Re: Objection to MP08_0244 MOD 1 Modification Request for Mixed Used Development at 23-37 Lindfield Avenue and 11 Havilah Lane, Lindfield

Major Projects Assessment
Department of Planning and Infrastructure
GPO Box 39, SYDNEY, NSW 2001

1 SHADOW DIAGRAM - 21stDEC_9AM
5003 SCALE1 : 650

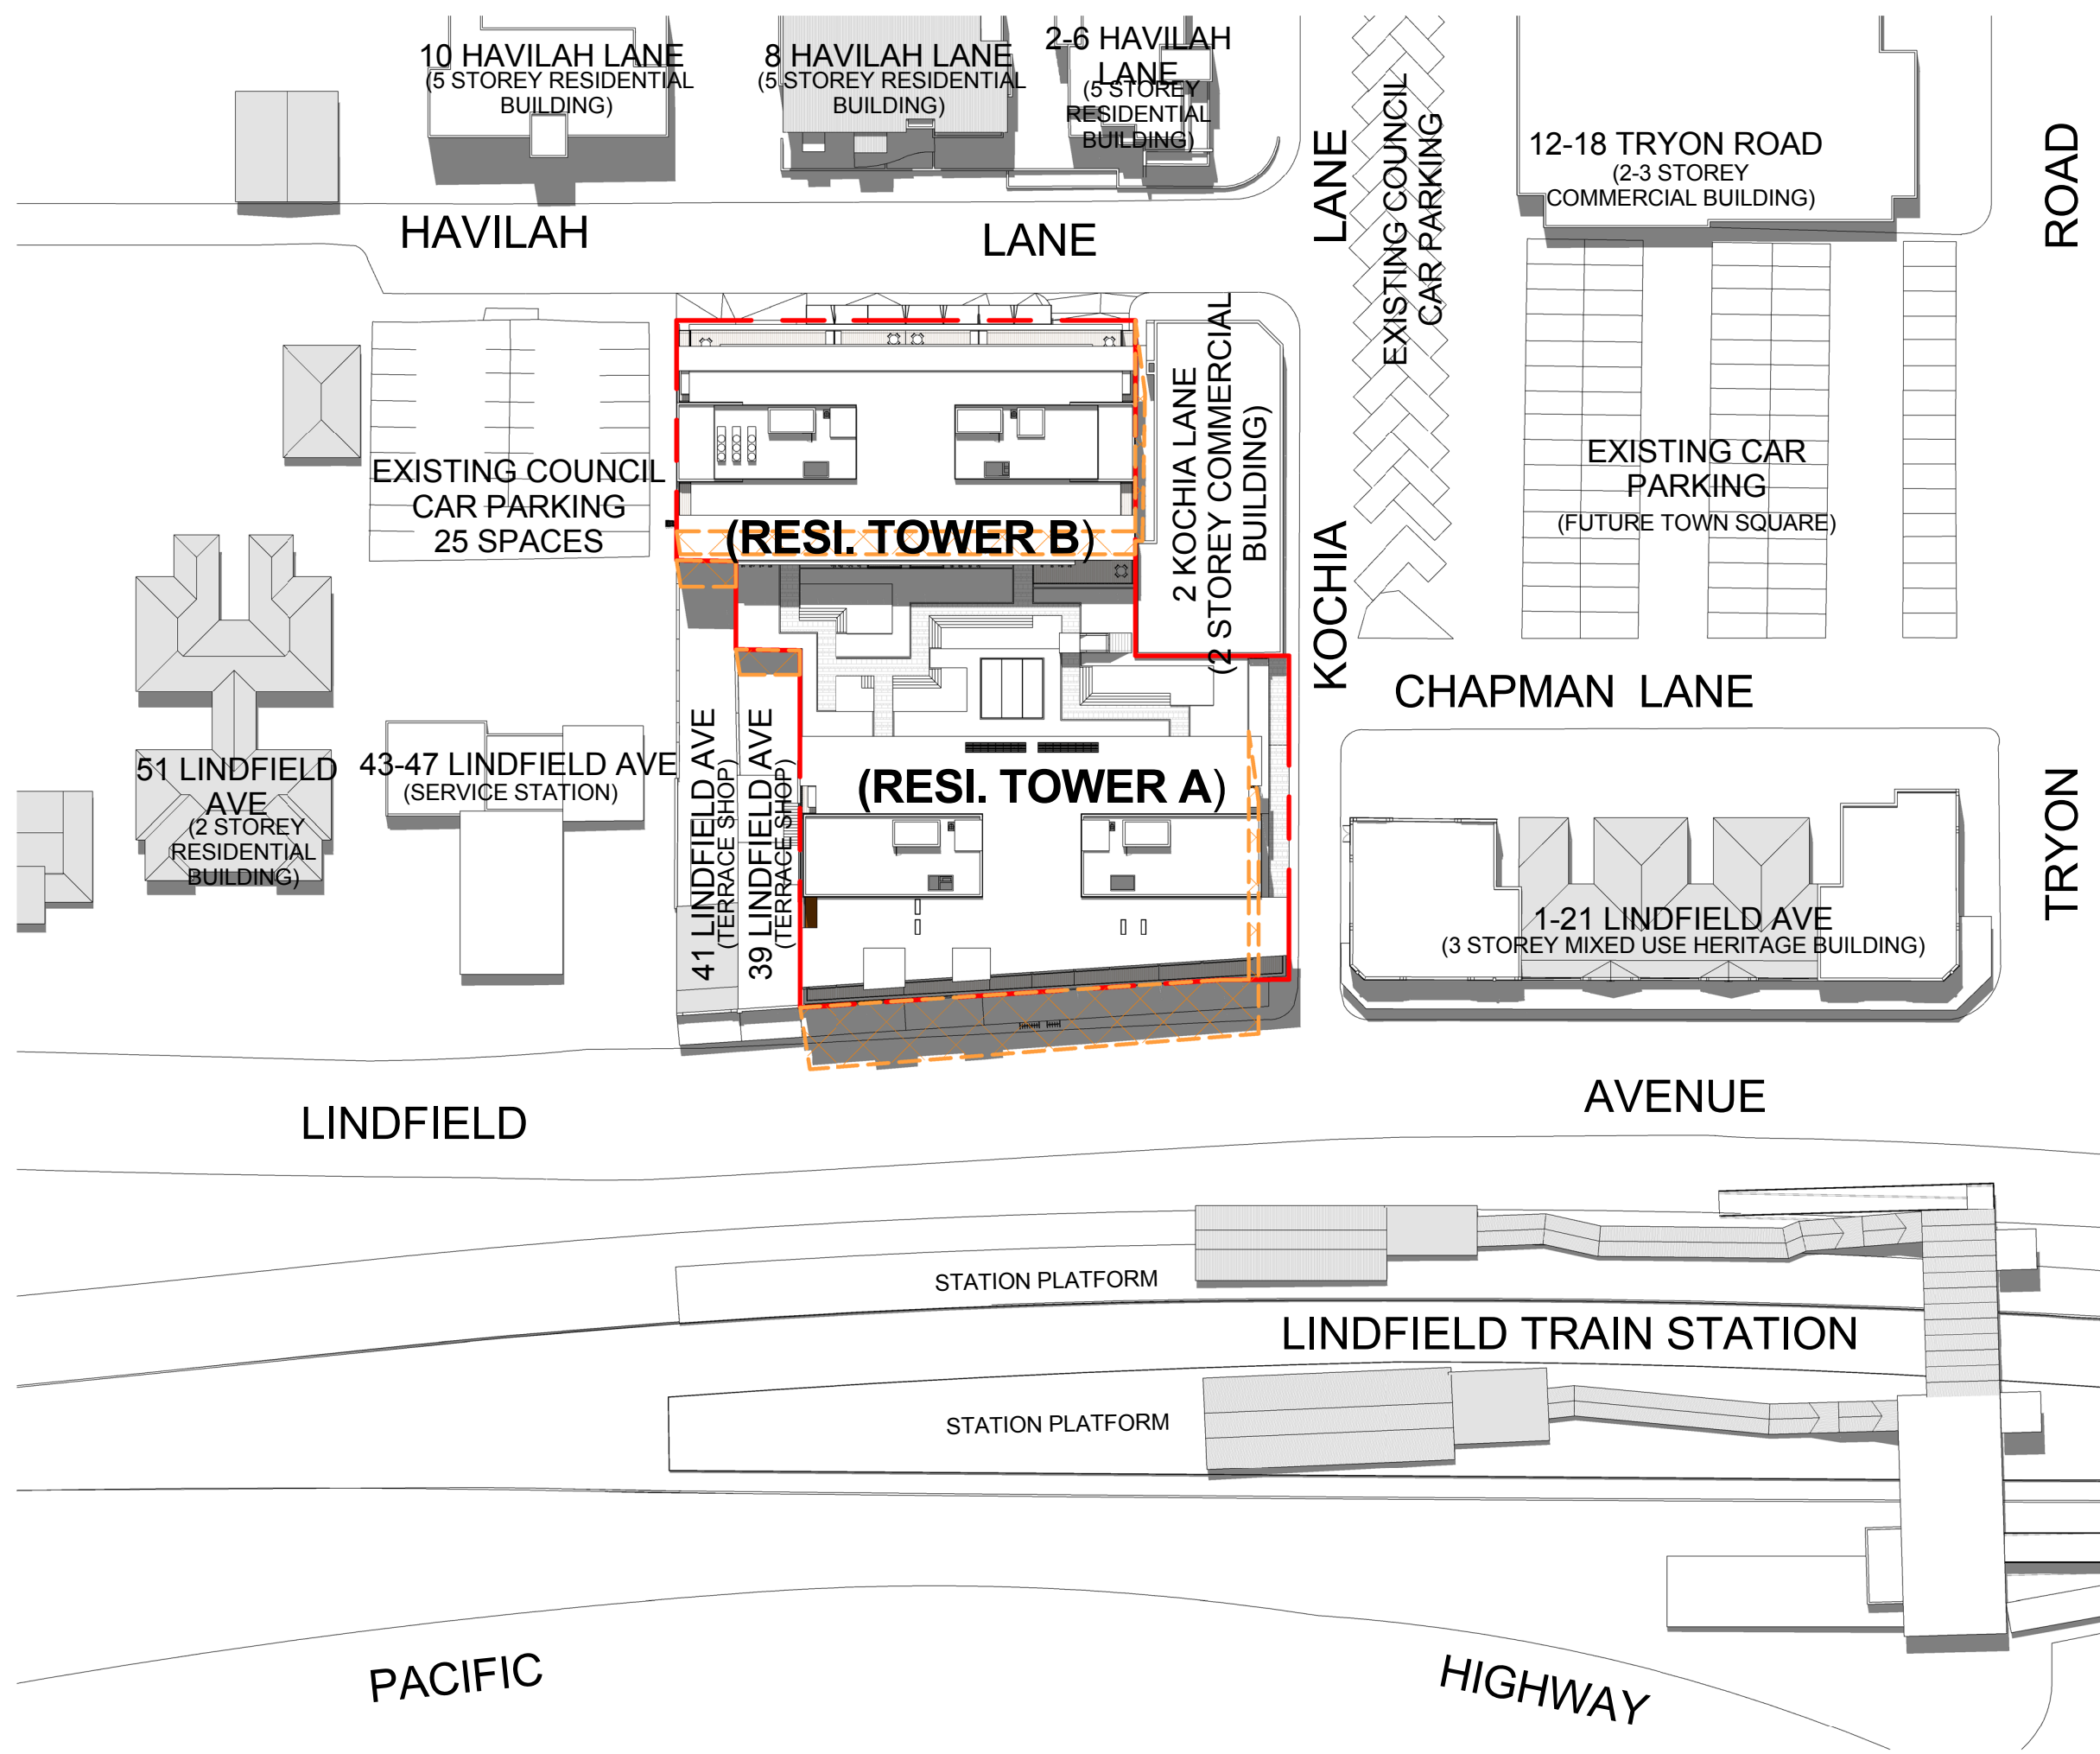
- The additional storeys create new adverse shadowing: a) for residents in the Havilah Lane apartments, particularly after 3pm b) for the popular outdoor café and central Lindfield hub area at 12 Tryon Road in afternoons, particularly in winter and c) for all commuters on the city bound Lindfield rail platform, instead of 50% of the year as approved, it will now be in shadow in the mornings 75% of the year

FIGURE 1.3 – MODIFIED SCHEME CAR PARKING

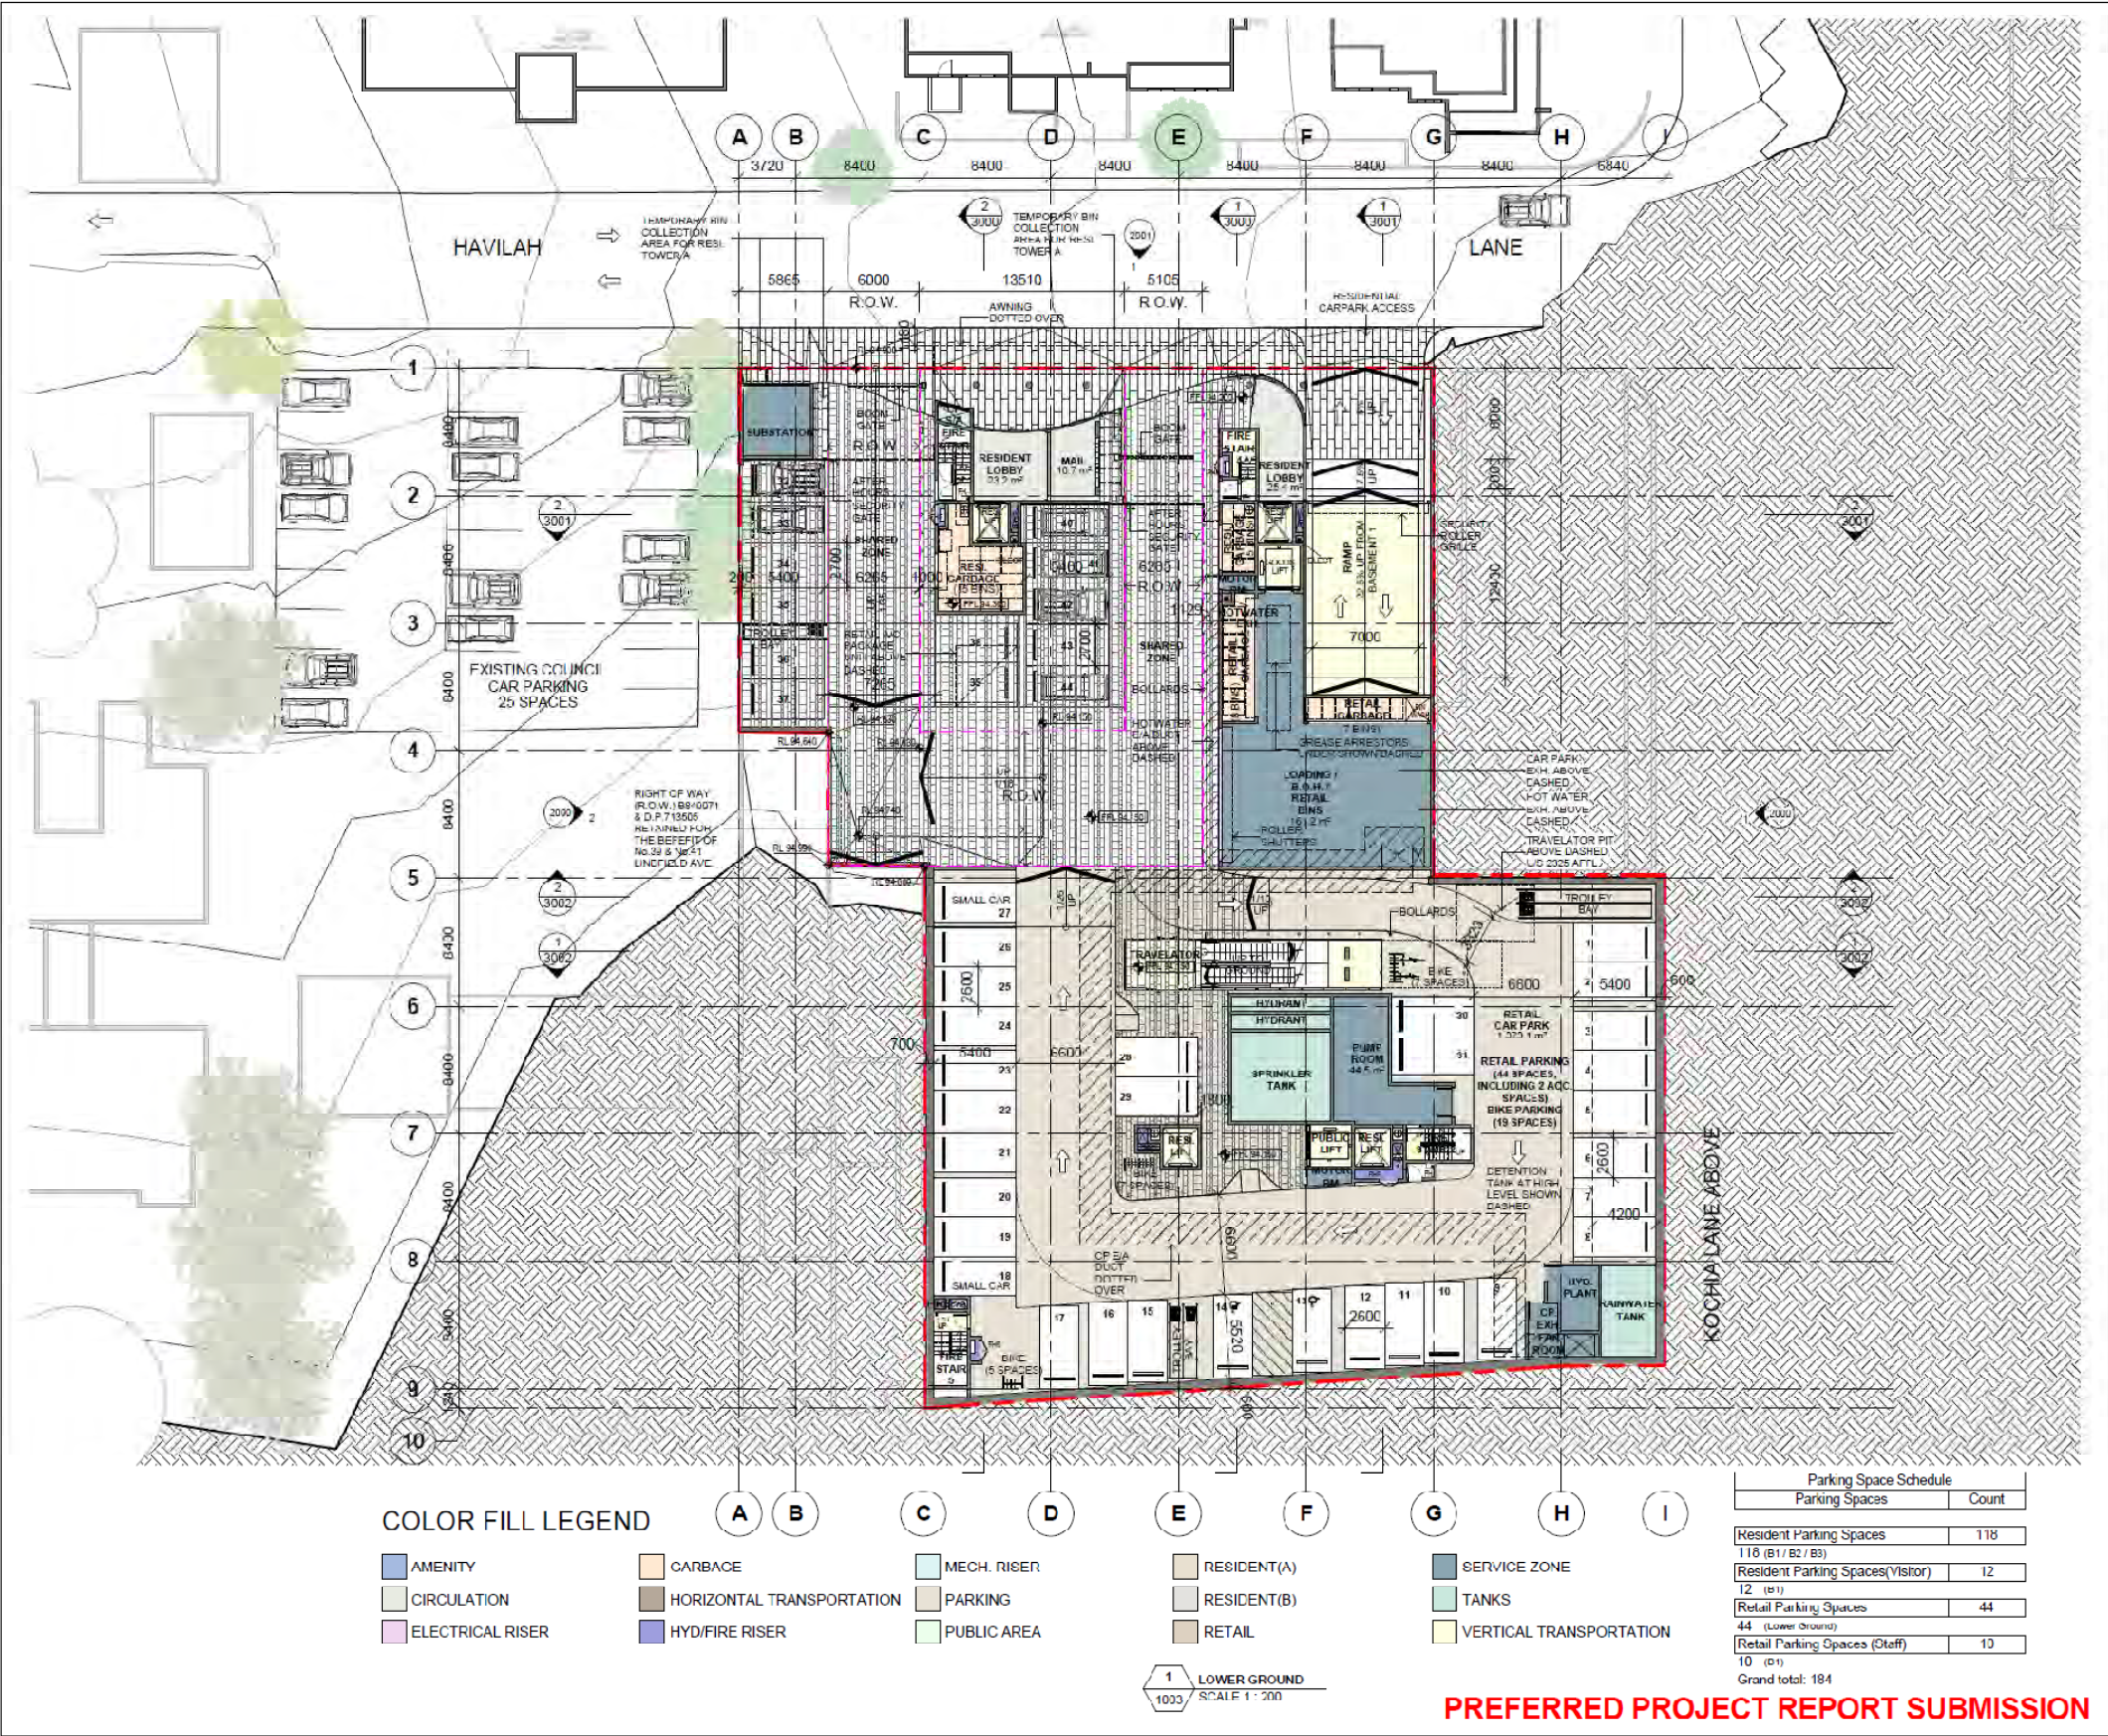
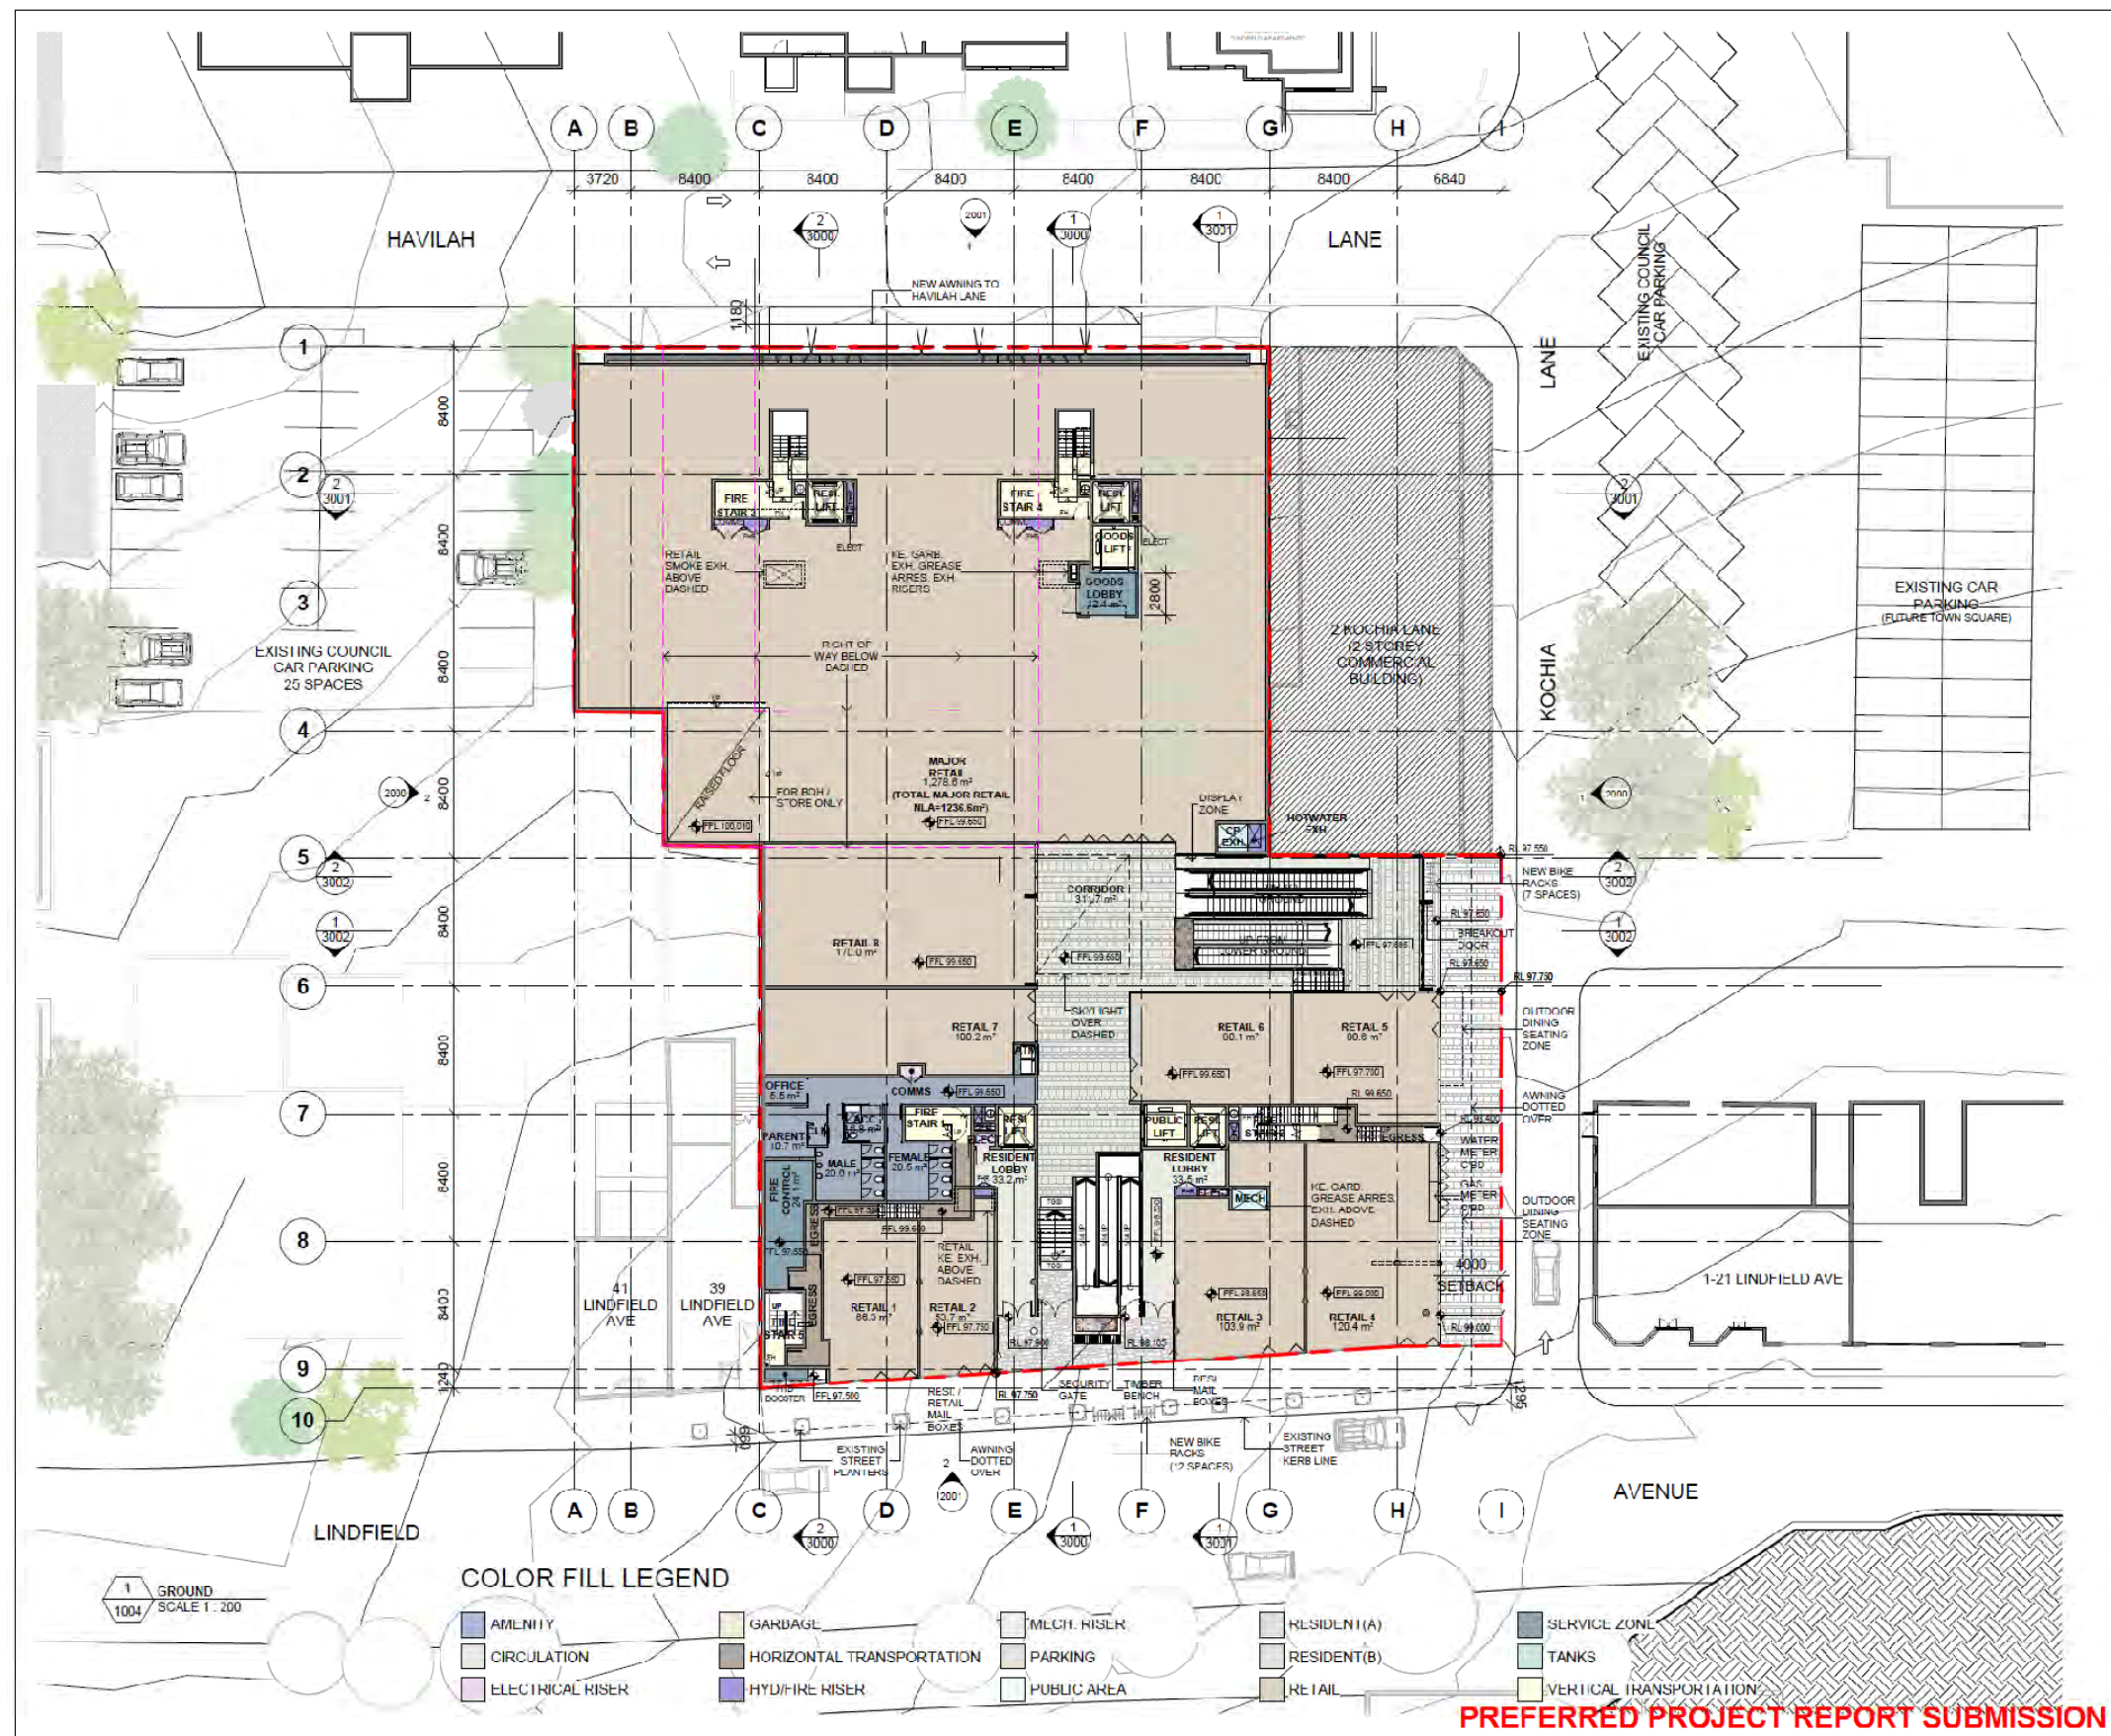
- Car spaces were identified as inadequate for the retail component and this has not been addressed relative to the remaining retail space proposed. The 25 car spaces counted as part of council's car park are also now highly uncertain due to the proposed rezoning and potential redevelopment.
